**ANGEL PLACE
LEVEL 8, 123 PITT STREET
SYDNEY NSW 2000**

26 May 2022

RESPONSE TO AGENCY COMMENTS | SSD-21190804 - JALCO MANUFACTURING FACILITY

Figure 14 Odour Impacts – Proposed Operations

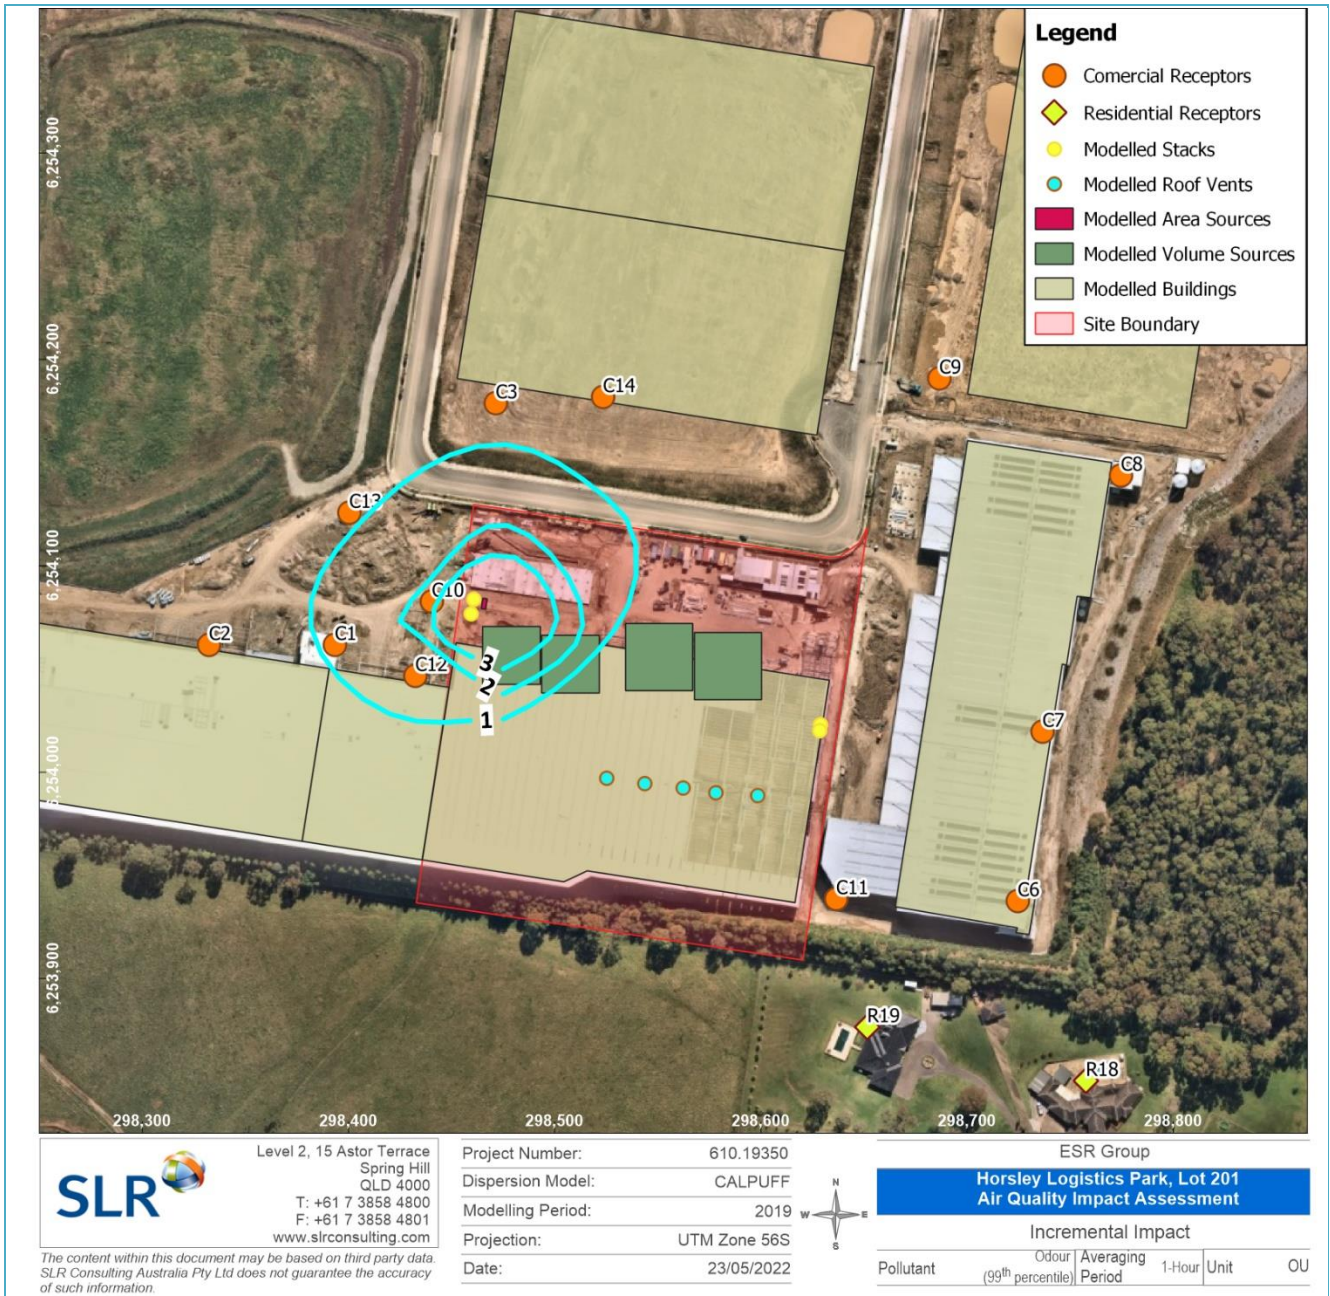
Table 11 Predicted Odour concentration at Residential Receptor and Figure 14 Odour Impacts, present within the report demonstrates the predicted odour impact that identified receivers are to experience. The Table displays that the odour concentration predicted at all surrounding residential receptors are below the relevant odour criteria of 2ou. It is then further indicated that all commercial receptors are predicted to experience odour concentrations (average across the entire	The adopted pollution control system design (refer Section 2.3 in Attachment C) is predicted to achieve compliance with the adopted odour impact assessment criteria at all locations with the exception of one carpark receptor, where the predicted odour concentration is 2.0 odour units (refer Section 7 in Attachment C).

Matter for Consideration	Response
commercial site) below the 2our criterion with the exception of receptor C1 which is predicted to experience an exceedance of 2.8 ou which the consultant considers marginal. A revised dispersion modelling assessment must include various pollution control strategies until compliance is achieved in accordance with the NSW EPA Approved Methods for Modelling and Assessment of Air Pollutant Guidelines.	It is noted that the adopted odour impact assessment criterion is conservative. Based on previous discussions with the NSW EPA, the odour impact assessment criterion is recommended to be determined through identifying the area within the two-odour unit isopleth and multiplying this area by the relevant average population density of 500 people per square kilometre for the Site, the affected population for the worst-case sensitivity scenario modelled would be less than 30, which means an odour impact assessment criterion of 5 ou may be appropriate.

The consultant has stated that the WWTP is identified to be a relatively large odour source, with a 28% contribution to total odour emissions from the site. A ground level impact contribution analysis was performed and revealed that the impacts from the WWTP ranged from <0.1ou to 0.4ou at the modelled residential receptors. There is no mention of the odour modelling impact of the WWTP undertaken on the identified commercial receptors. The consultant shall also undertake an odour modelling impact contribution analysis and present the ground level concentration contribution of the WWTP will have on modelled commercial receptors.	Refer to Section 7 in Attachment C Air Quality Impact Assessment for source contribution for all receptors.
An odour control strategy for the WWTP has been provided by the consultant which demonstrates an approximate 50-90 per cent reduction in odour impacts at	Given the proximity of the WWTP to the worst impacted commercial receptors, higher odour reductions are predicted for these commercial receptors. Refer to Section 7 in Attachment C for further information.
